**COUNTY OF HARNETT RESIDENTIAL LAND USE APPLICATION**  
Central Permitting 108 E. Front Street, Lillington, NC 27546 Phone: (910) 893-7525 ext:2 Fax: (910) 893-2793 www.harnett.org/permits

PROPERTY LOCATION: Subdivision: RIVER RIDGE Lot #: 4B Lot Size: 10.051 AC  
State Road # LOT 4B State Road Name: River Ridge Rd Map Book & Page: 99, 601  
Parcel: 13 0602 0139 08 PIN: 0612-49-4726.000  
Zoning: RASD Flood Zone: X Watershed: NA Deed Book & Page: 3408, 180 Power Company\*: \_\_\_\_\_

**Re: Status of Improvement Permit & Well Permit Applications # 17-5-40947**

SITE PLAN APPROVAL

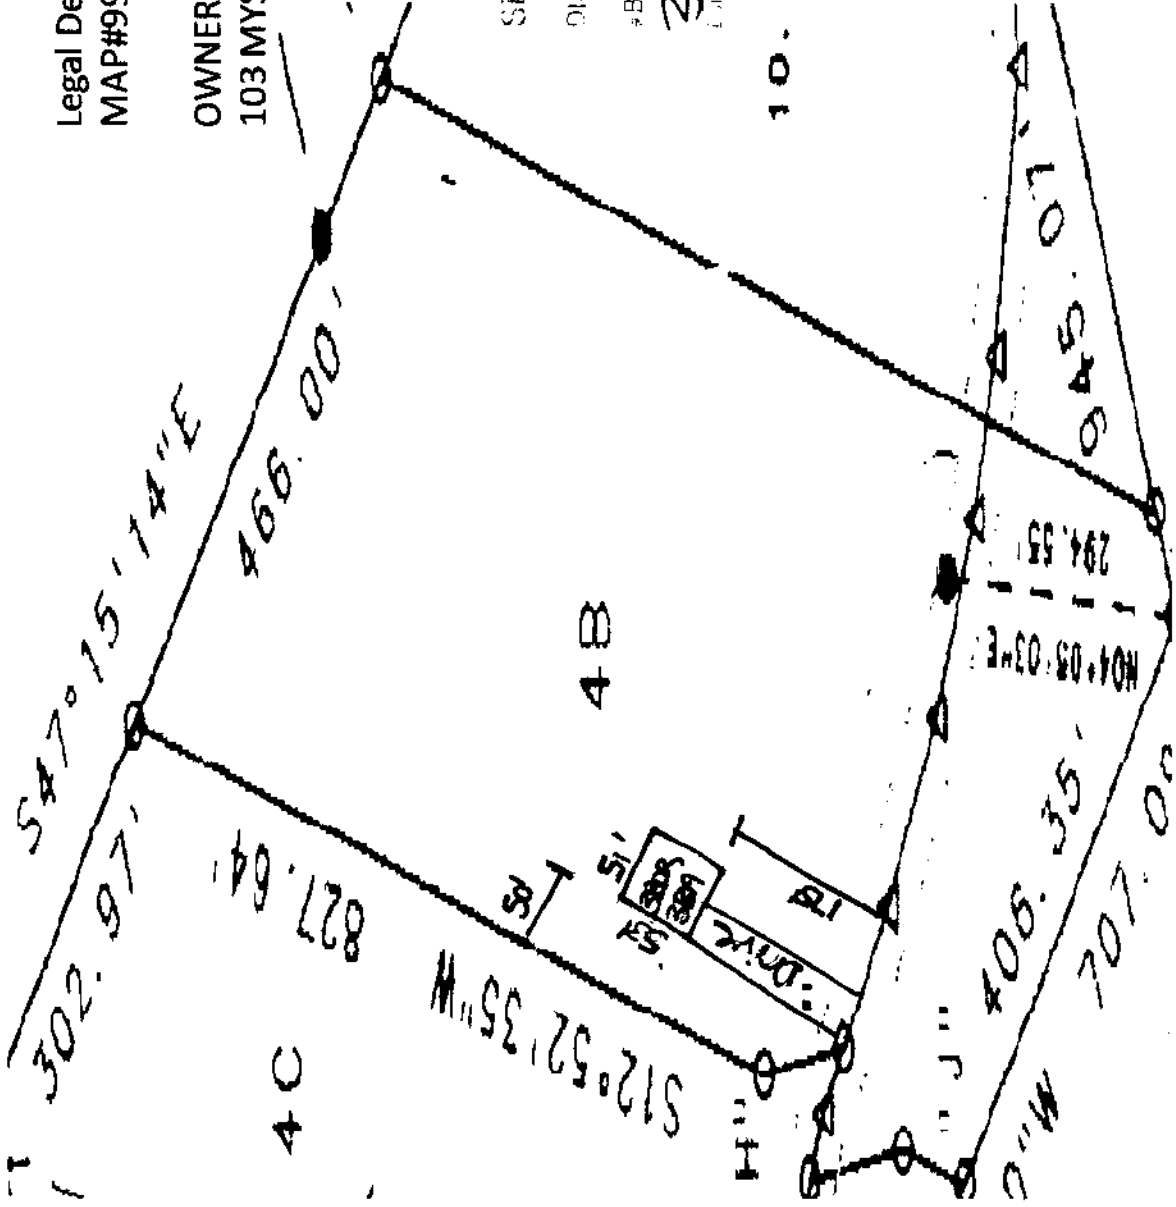
- 1. Use pink flags to mark property lines and irons that are set by surveyor need to be visible (\$25.00 fee incurred)**
- 2. Use orange flags to mark house corners (\$25.00 fee incurred)
- 3. Directions not clear to property (\$25.00 fee incurred)
- 4. Property needs only brush or vegetation removed
- 5. Driveway not shown on site plan
- 6. Backhoe pits required**
- 7. Other – No proposed septic or well area.**
